DECISION DELEGATED TO DEVELOPMENT MANAGER

Application No: H08-0131-21 **Applicant:** Mr S Benjamin
Proposal: Erection of Garage/Workshop & Irrigation Pond
Location: Neldar North Gate Gosberton
Terminal Date: 22nd May 2021

Nelder, North Gate, Gosberton, Spalding, Lincolnshire, PE11 4LJ

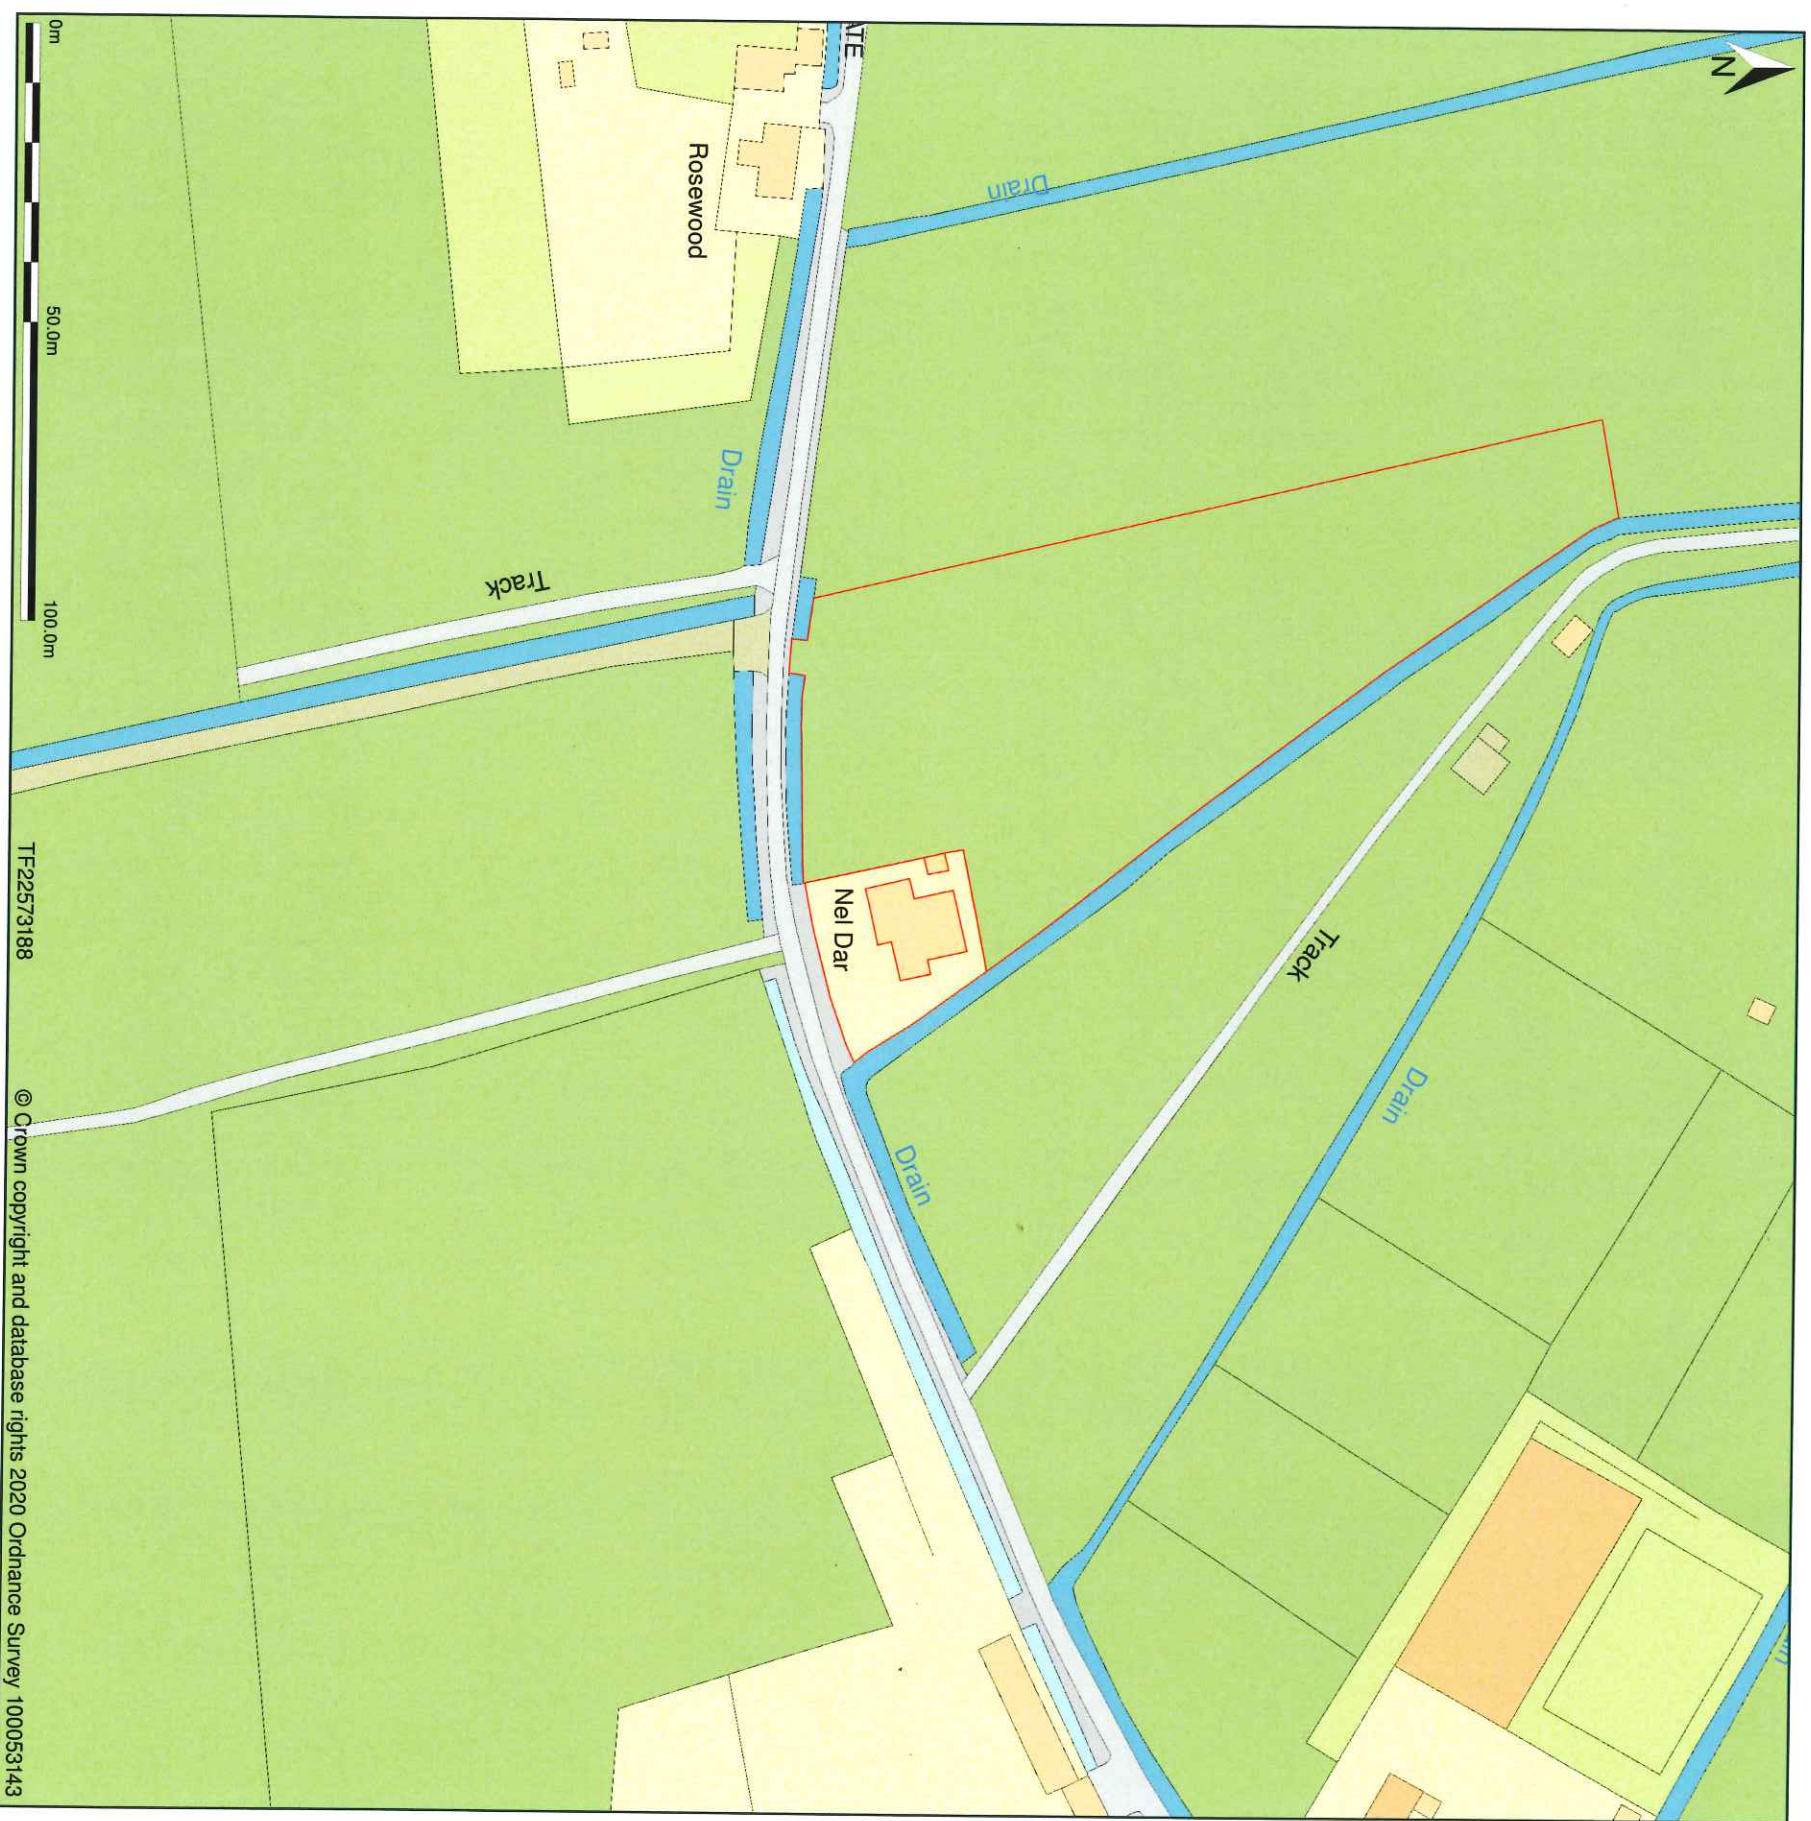
"The plan doesn't show depth, bunding height or propose fencing around pond. Due to the vicinity to the road and type of liner proposed without fencing this could be a risk of drowning. Also without proper plans the visual impact of the irrigation pond can not be judged. If this was rectified I wouldn't have an objection."

2. The design of the garage / workshop is of a standard construction and will be brick and tile. The garage would be conditioned to have matching brick and tile to that of the dwelling. The siting of the garage is toward the front of the site, but in line with the front elevation of the bungalow. This is considered to be an appropriate location. The pond will be conditioned to have a fence around it to prevent accidental ingress and a ladder to aid egress should anyone be trapped in the pond.
